**From:** [Rodenbeck, Jay B.](#)  
**To:** [Gutierrez G. David](#)  
**Cc:** [Rose, Robyn L.](#); [Webb, Robert L.](#); [Boylan, Jacob](#); [Roddenbeck, Jay B.](#)  
**Subject:** FW: DFT Meeting: November 6th Comments for Item #3\_PR- 2024-010074\_SI-2024-01533  
**Date:** Thursday, January 30, 2025 6:30:00 PM  
**Attachments:** [image004.png](#)  
[image005.png](#)  
[image001.png](#)  
[Cottonwood Storage LS-101h-PL.PDF](#)  
[Cottonwood Storage LS-101h-IDO.PDF](#)  
[Cottonwood Storage LS-101h-DH.pdf](#)  
[Cottonwood Storage LS-101h-IRR.PDF](#)  
[Survey.pdf](#)  
[2024014-GR-1.pdf](#)

**From:** Regina Okoye <[rokoye@modulusarchitects.com](mailto:rokoye@modulusarchitects.com)>  
**Sent:** Friday, January 24, 2025 11:26 AM  
**To:** Gutierrez, David G. <[dggutierrez@abcwua.org](mailto:dggutierrez@abcwua.org)>  
**Cc:** Rodenbeck, Jay B. <[jrodenbeck@cabq.gov](mailto:jrodenbeck@cabq.gov)>; Webb, Robert L. <[rwebb@cabq.gov](mailto:rwebb@cabq.gov)>; Boylan, Jacob <[jboylan@cabq.gov](mailto:jboylan@cabq.gov)>  
**Subject:** RE: DFT Meeting: November 6th Comments for Item #3\_PR- 2024-010074\_SI-2024-01533

**Subject:** DFT Meeting: November 6th Comments for Item #3\_PR- 2024-010074

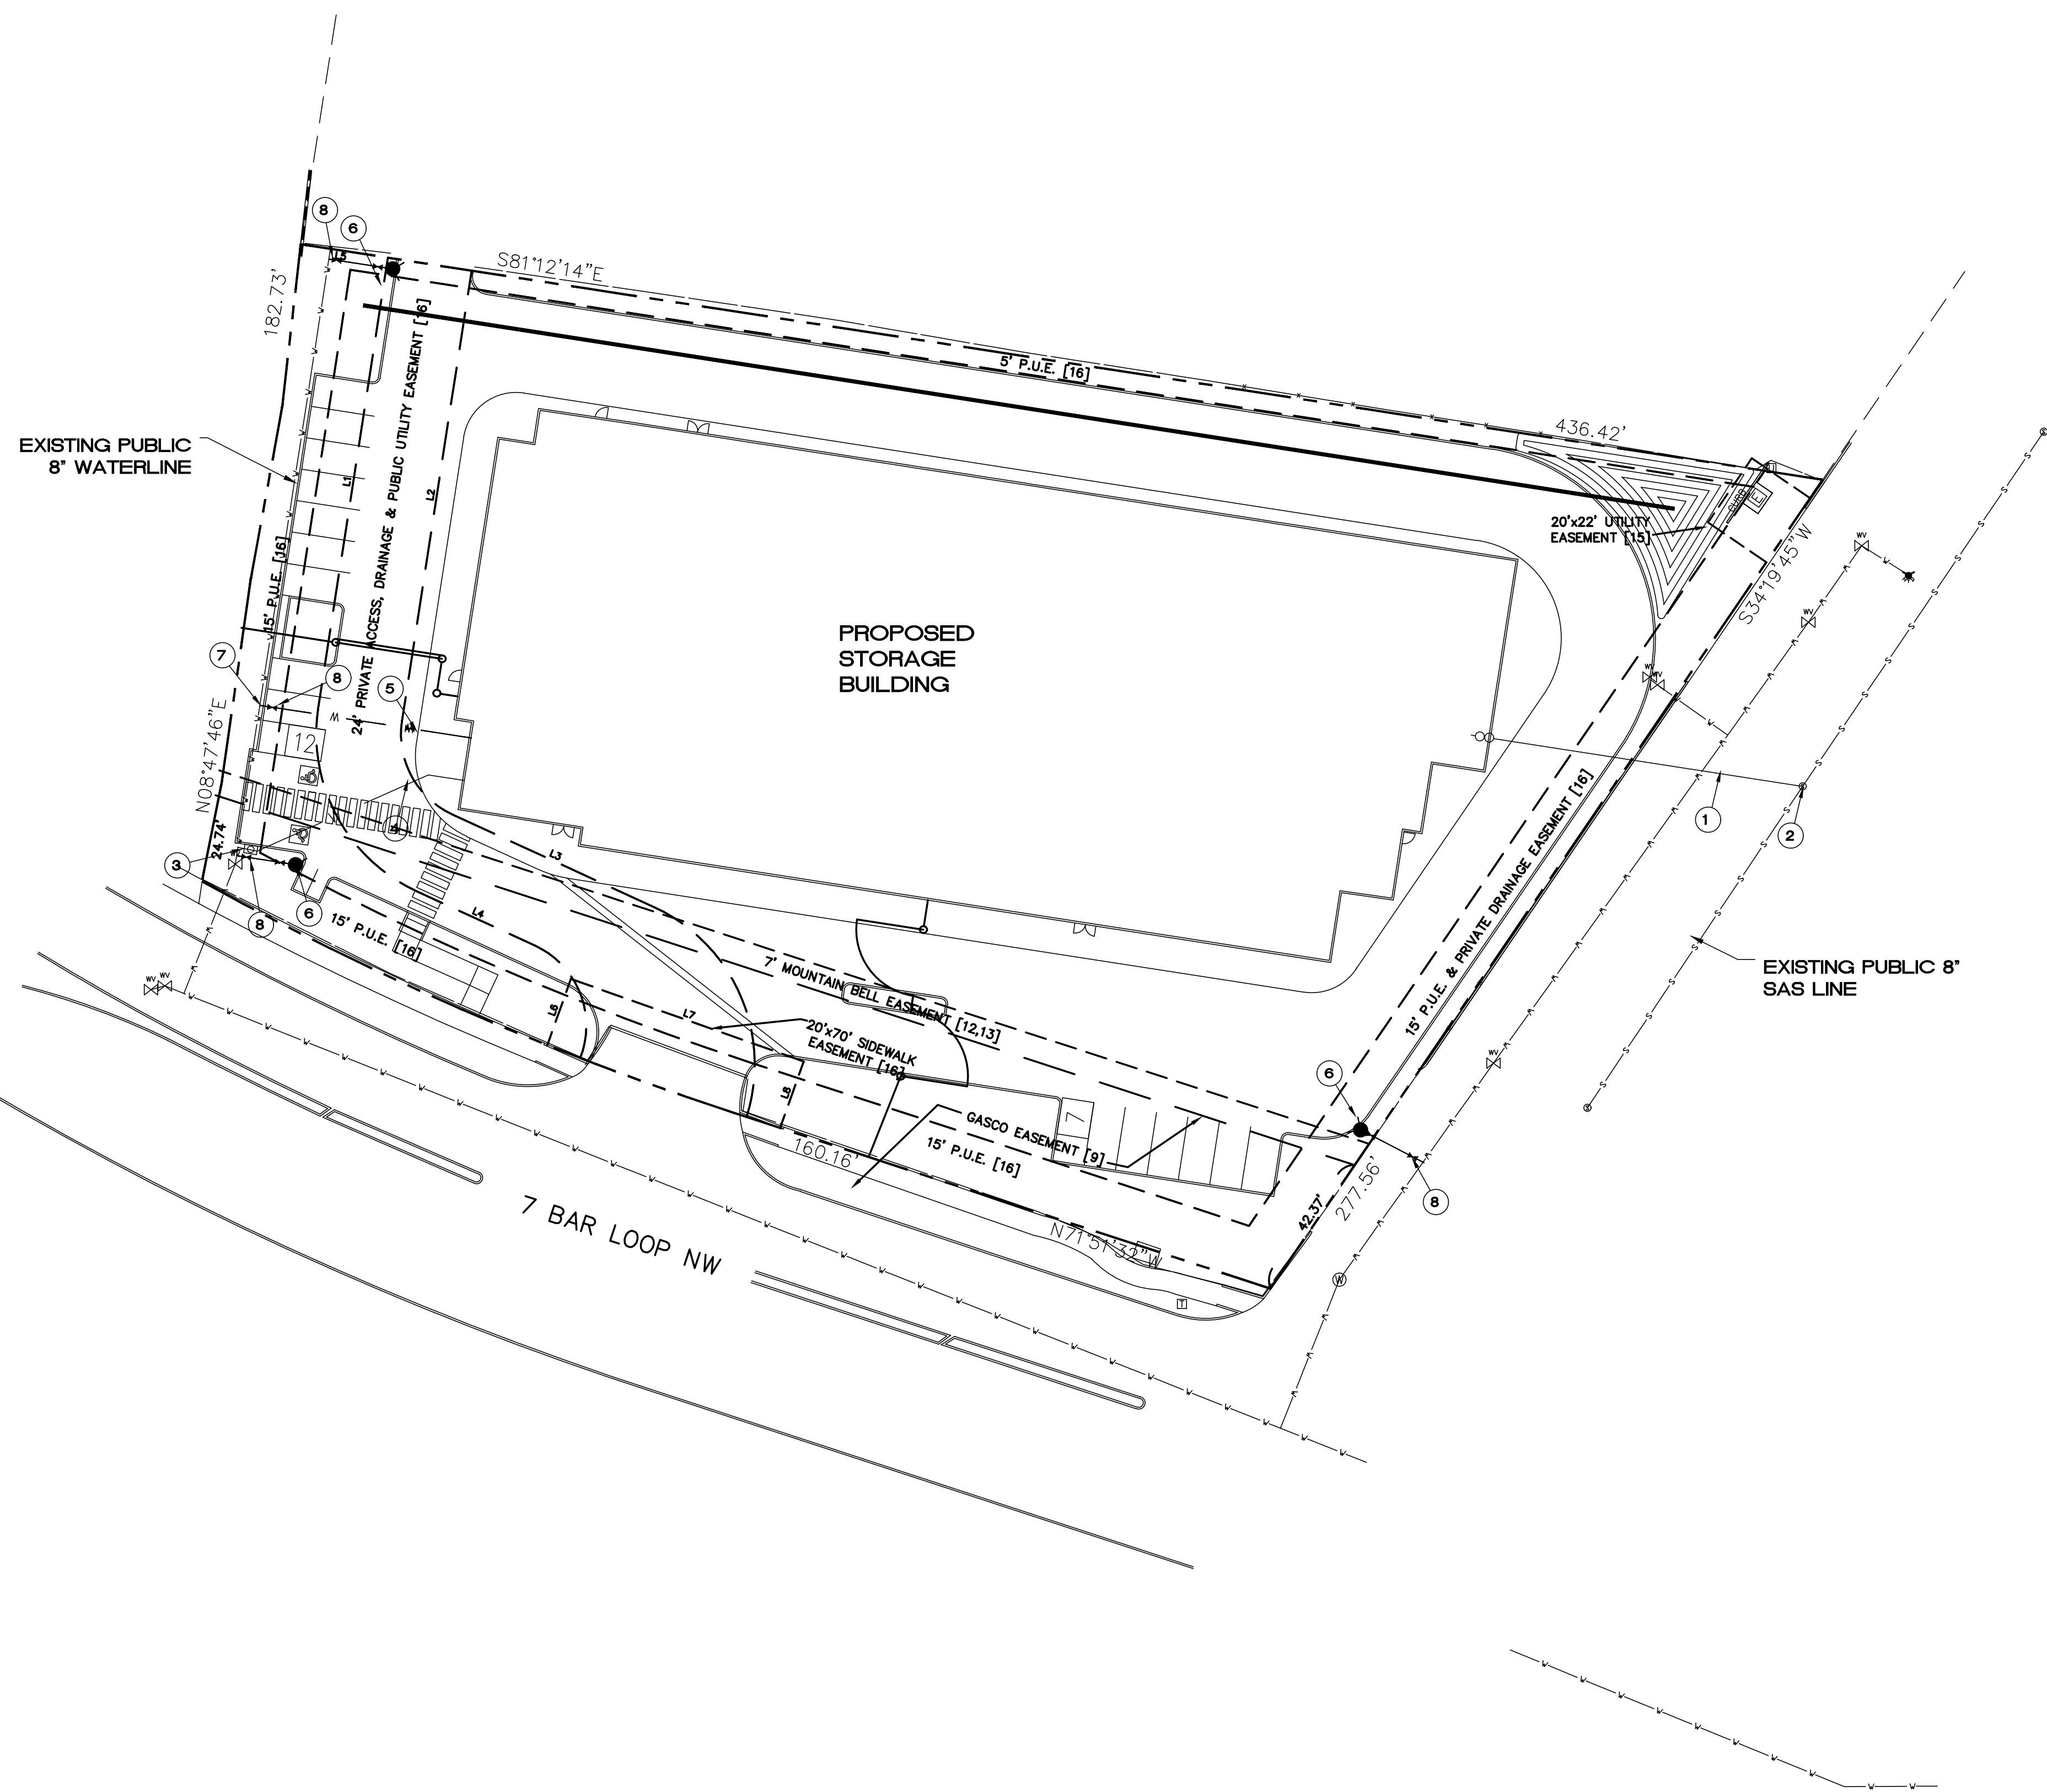
It looks like the current utility plan shows the public waterline directly adjacent to parking and the curb and gutter. I did not see how this was addressed from my comments. This line can potentially be relocated through the drive isle to avoid this. I would also like to see the landscape plan to see what you are proposing in that. Additionally, we want 20 ft easement for the infrastructure and the current easement is 20 ft.

Attached is the plat that you requested for this application showing the easement along the west side of the property. The existing easement was dedicated in 2006 as a PUE. The PUE includes verbiage for the water and sewer lines. I have attached and highlighted the areas in question. Will this suffice to address your concerns on the easement verbiage?

Also, all the comments that were received in this round were addressed in the prior submittal. I have marked the areas in red for reference on the Utility Plan.
